East Anglia One North (EA1N) and East Anglia Two (EA2) Offshore Wind Farms

Planning Inspectorate Reference: EA1N – EN010077, EA2 – EN010078

Deadline 5 – 3 February 2021

**Comments of Suffolk County Council as Archaeological Authority**

Outline Landscape Mitigation Plan

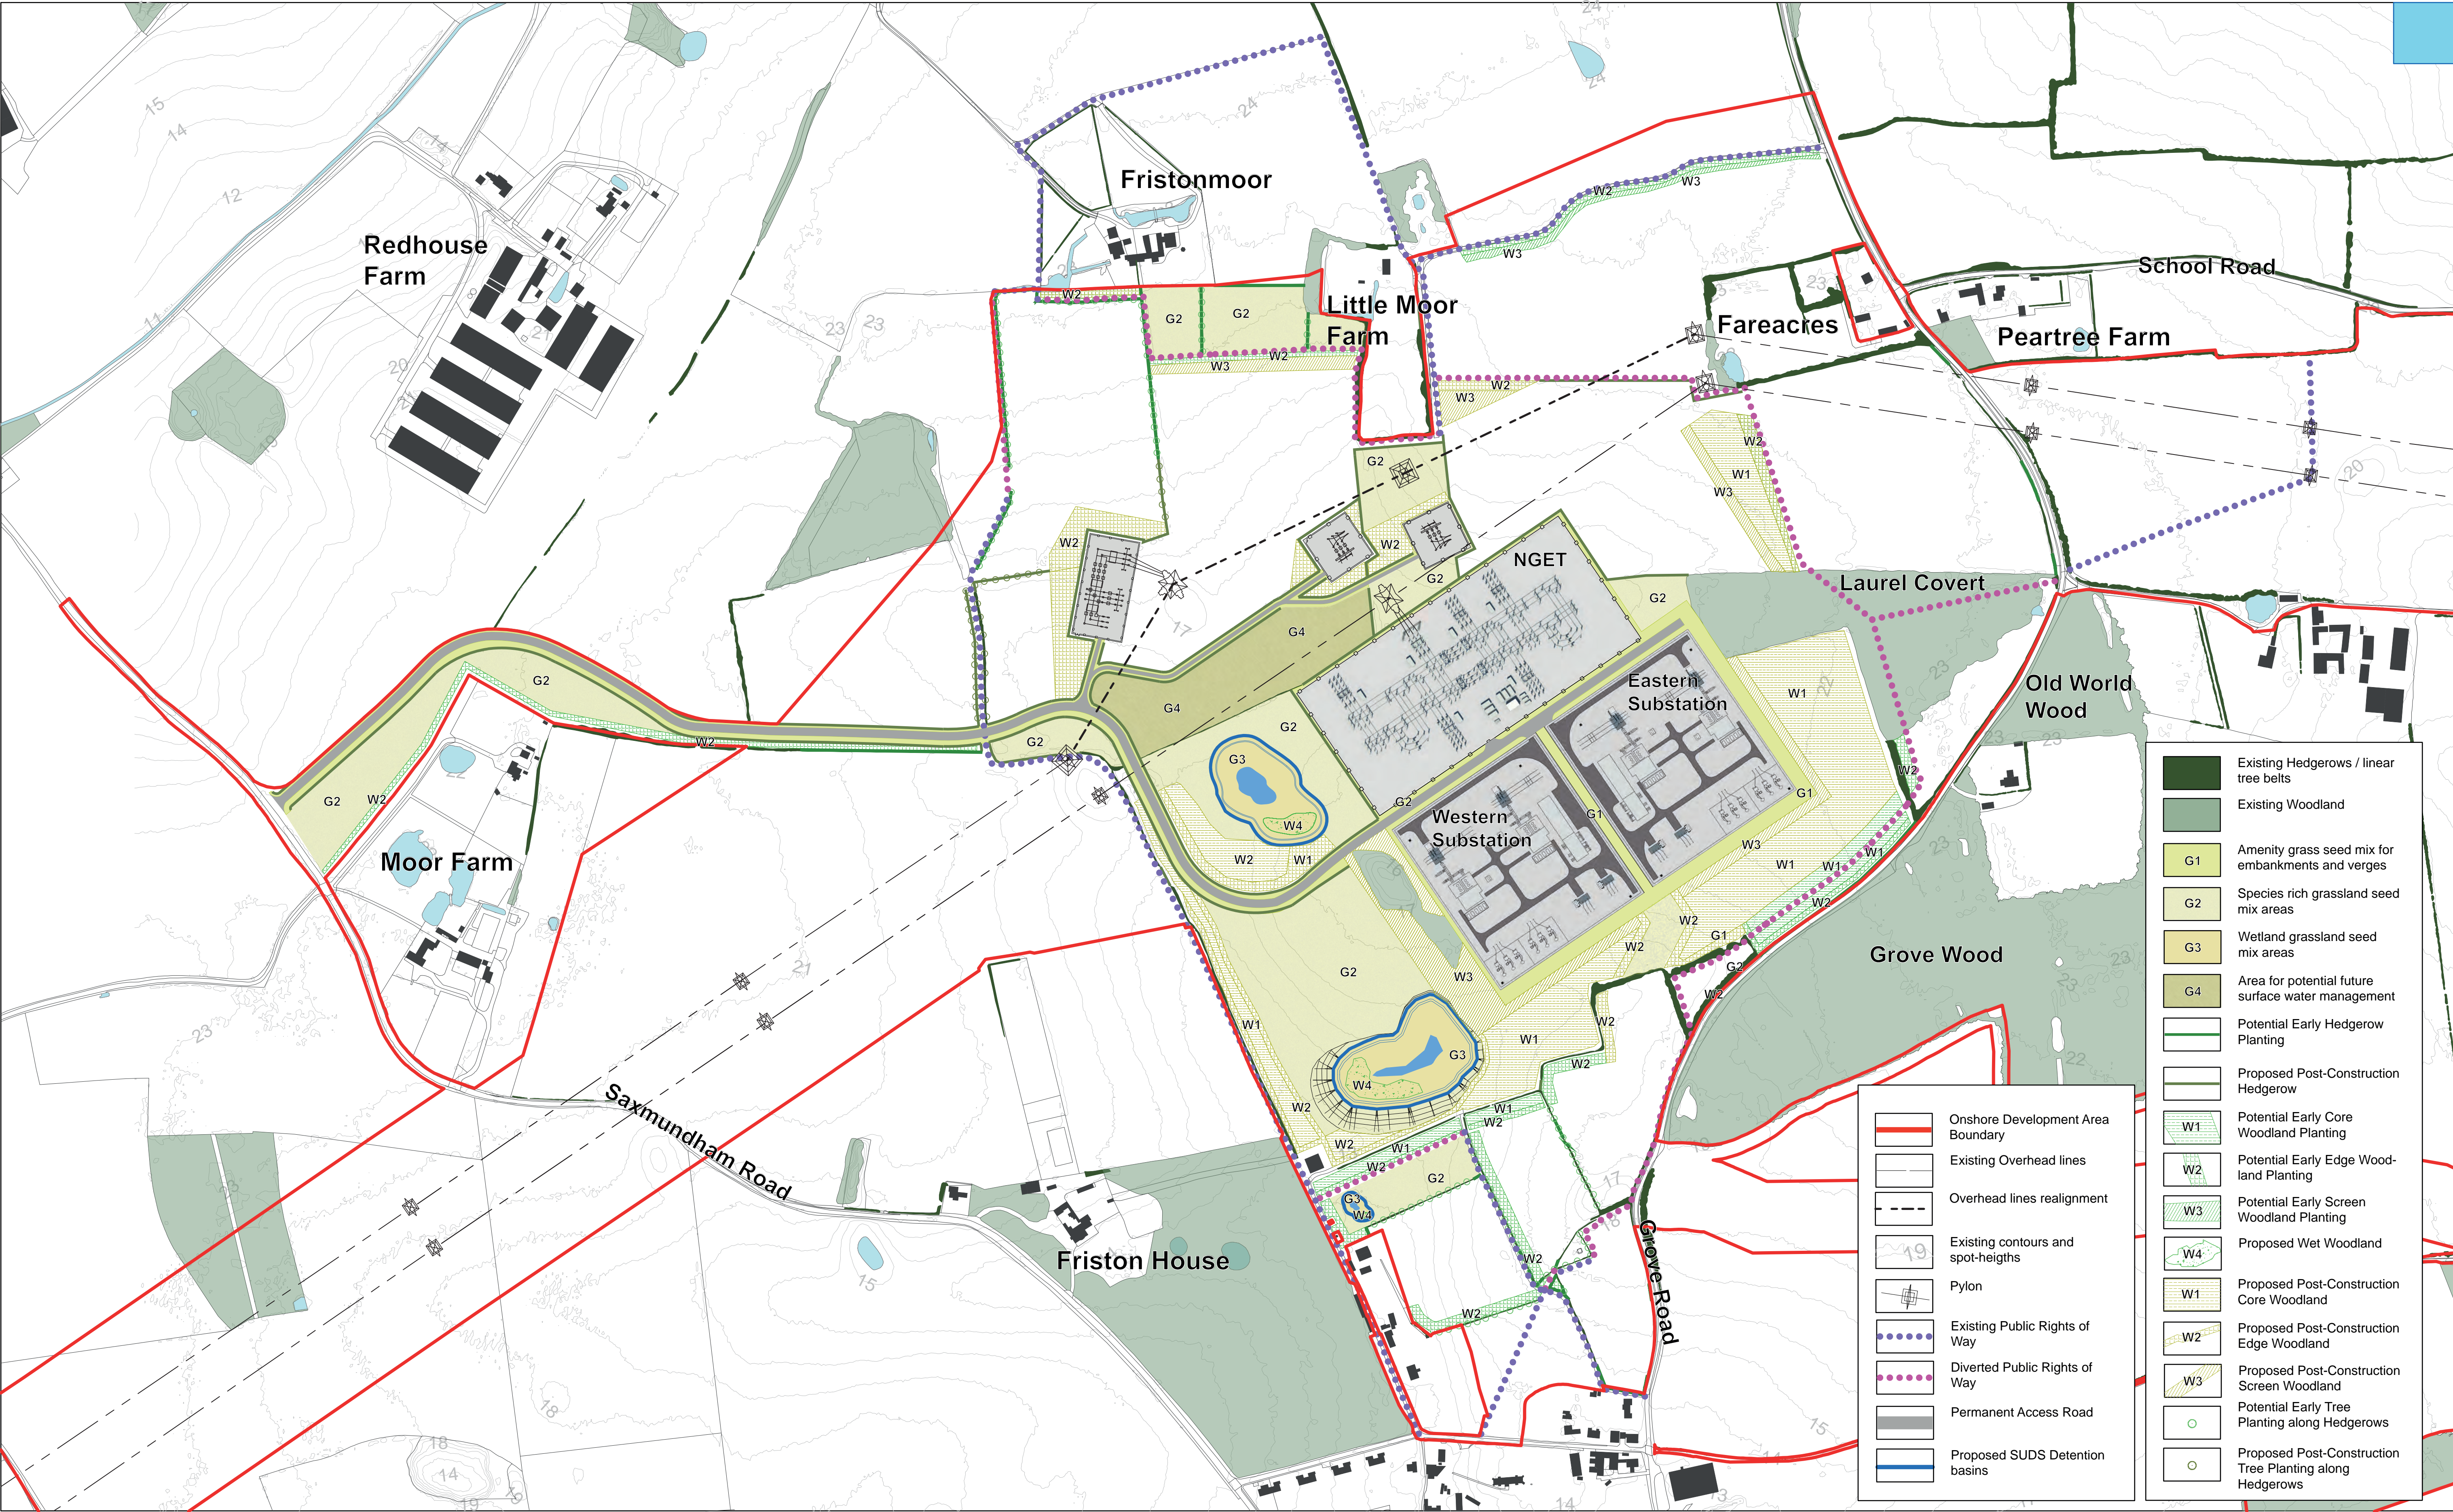
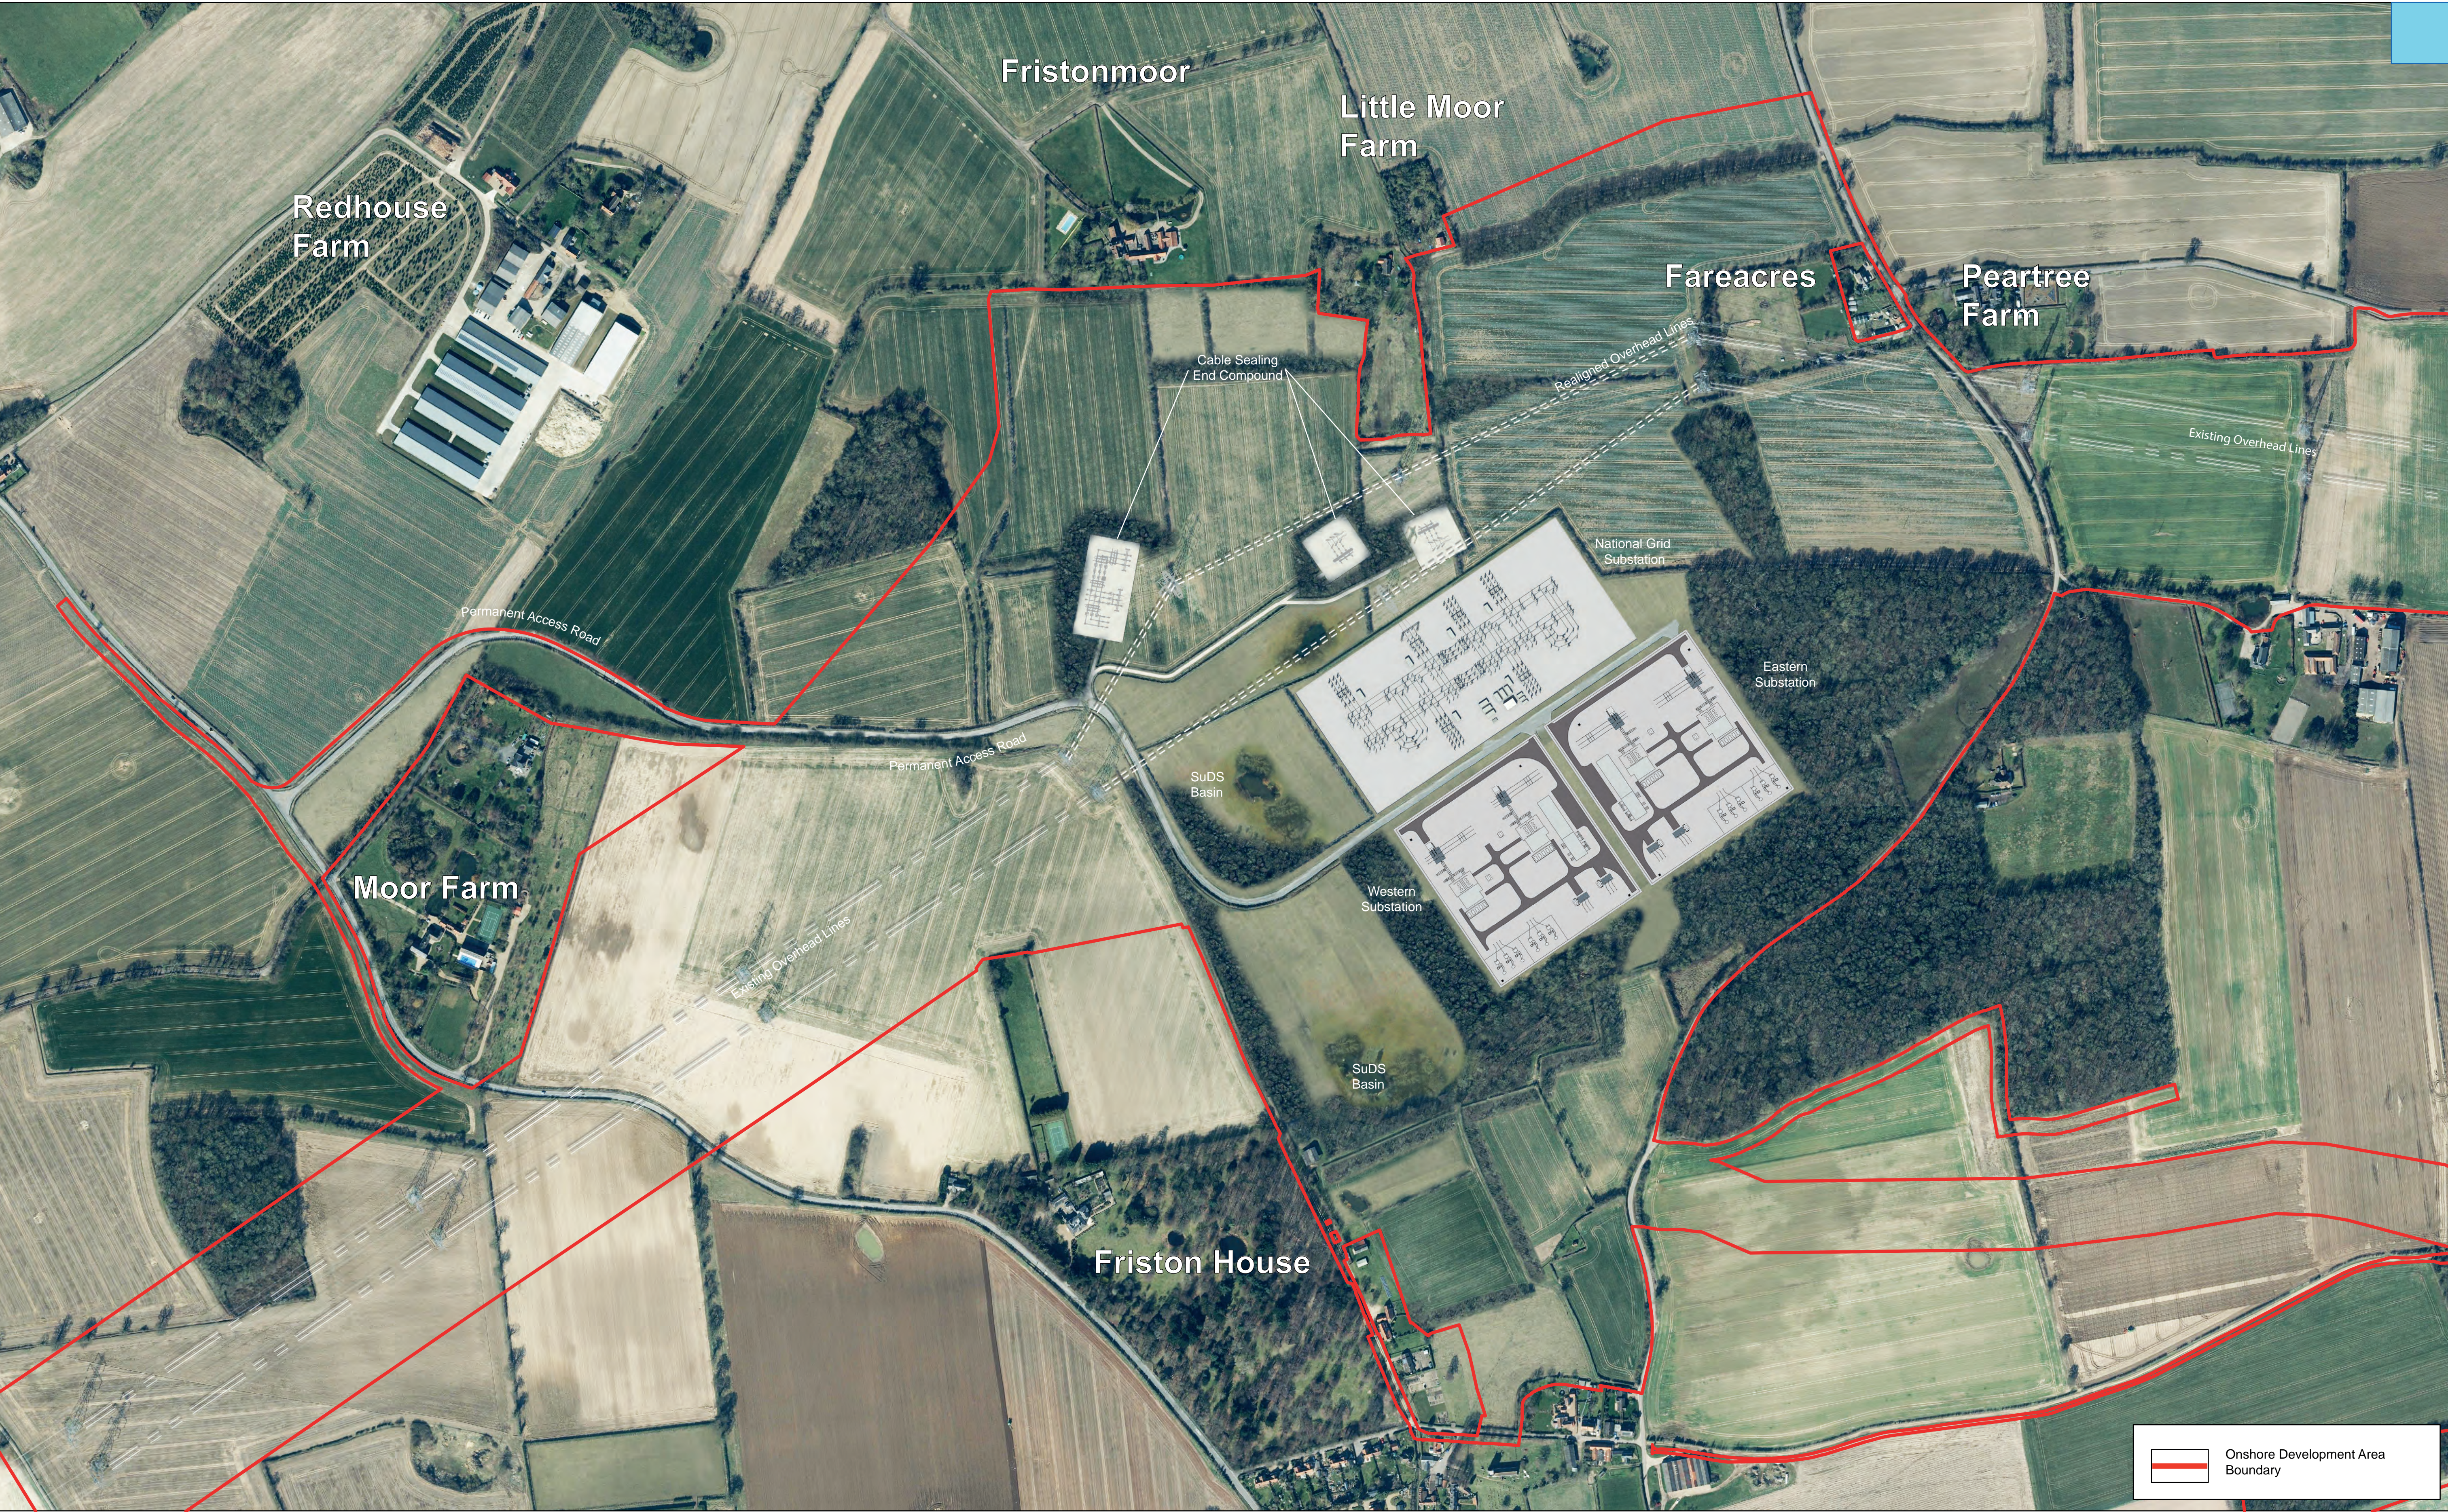
SCC would highlight that archaeological mitigation should be undertaken prior to any agreed landscape mitigation works, including any tree planting areas.
